Office of Environment & Heritage

DOC19/349603
SSD 8699

Redevelopment of Greenwich Hospital (SSD 8699) - Aboriginal cultural heritage

Figure 4.4 Map of the study area showing areas of Aboriginal archaeological potential. (Source: SIX Maps with GML additions 2017)

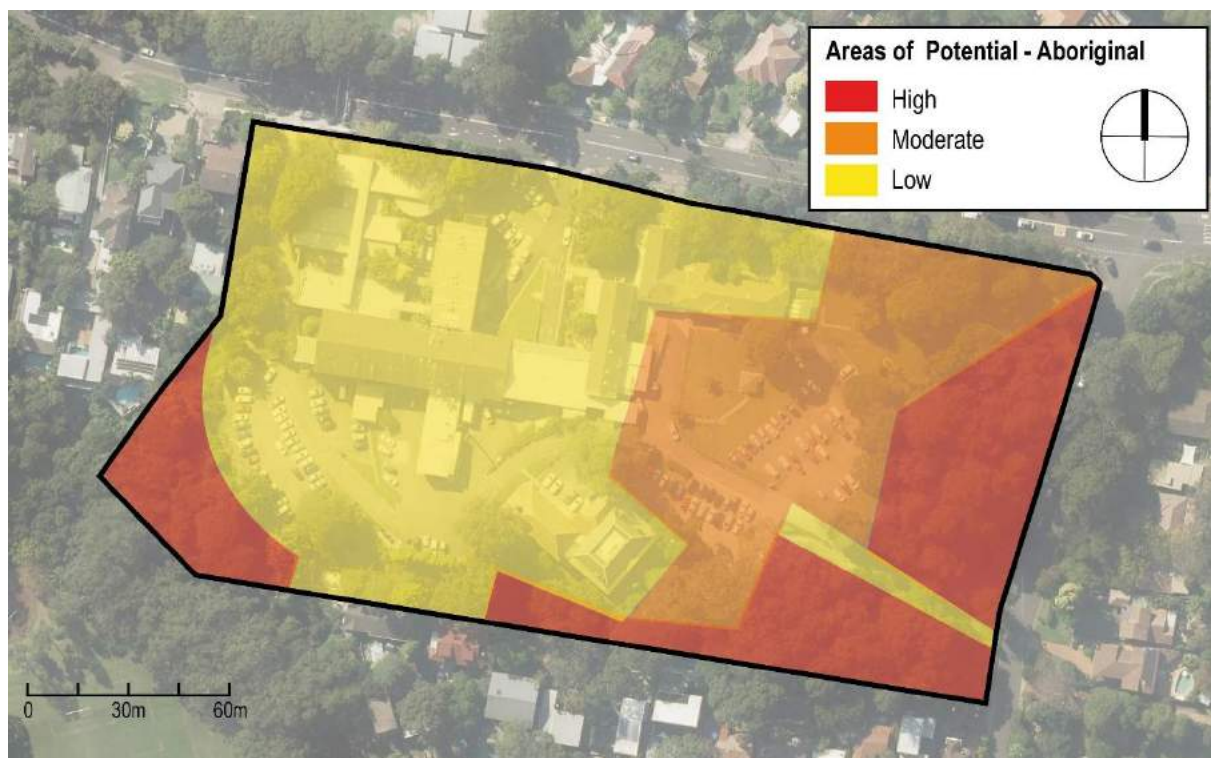
In summary, OEH advises that further assessment, including subsurface archaeological testing, should be completed in the area of archaeological potential mapped along the eastern side of the project area at an early stage of the project and prior to any ground disturbing impacts. Early assessment is recommended to ensure that impacts to Aboriginal cultural heritage are known and appropriate management strategies can be developed. This area was identified as having potential due to the presence of rock overhangs and has been recorded as less disturbed compared to the remainder of the project area. CHC has determined that the remainder of the project area is located at the top of a high gradient slope and is therefore unlikely to preserve intact archaeological deposits. The construction of the existing hospital and Pallister house and grounds would have also caused disturbance to any archaeological deposit located in these areas.

No Aboriginal objects have been recorded in the study area, however, the potential for objects to be present has been noted, particularly in the eastern portion of the project area. The potential for archaeological deposit in rock overhangs that were not able to be accessed during the survey has specifically been recorded. The visibility at the time of the survey was also noted to be low. OEH supports the CHC recommendations to complete additional survey of the project area if access to areas of rock overhangs is improved. An AHMP could guide this process.

OEH advises that further assessment, including subsurface archaeological testing, should be completed in the area of archaeological potential along the eastern side of the project area at an early stage of the project and prior to any ground disturbing impacts.

It is important to undertake archaeological testing at an early stage of the project to determine if harm to Aboriginal objects is likely to occur. It is recommended that any testing is undertaken prior to the development of an AHMP. The results of the testing could inform the management and mitigation strategies outlined in the AHMP. Only those areas of potential that are proposed to be subject to harm should be tested.
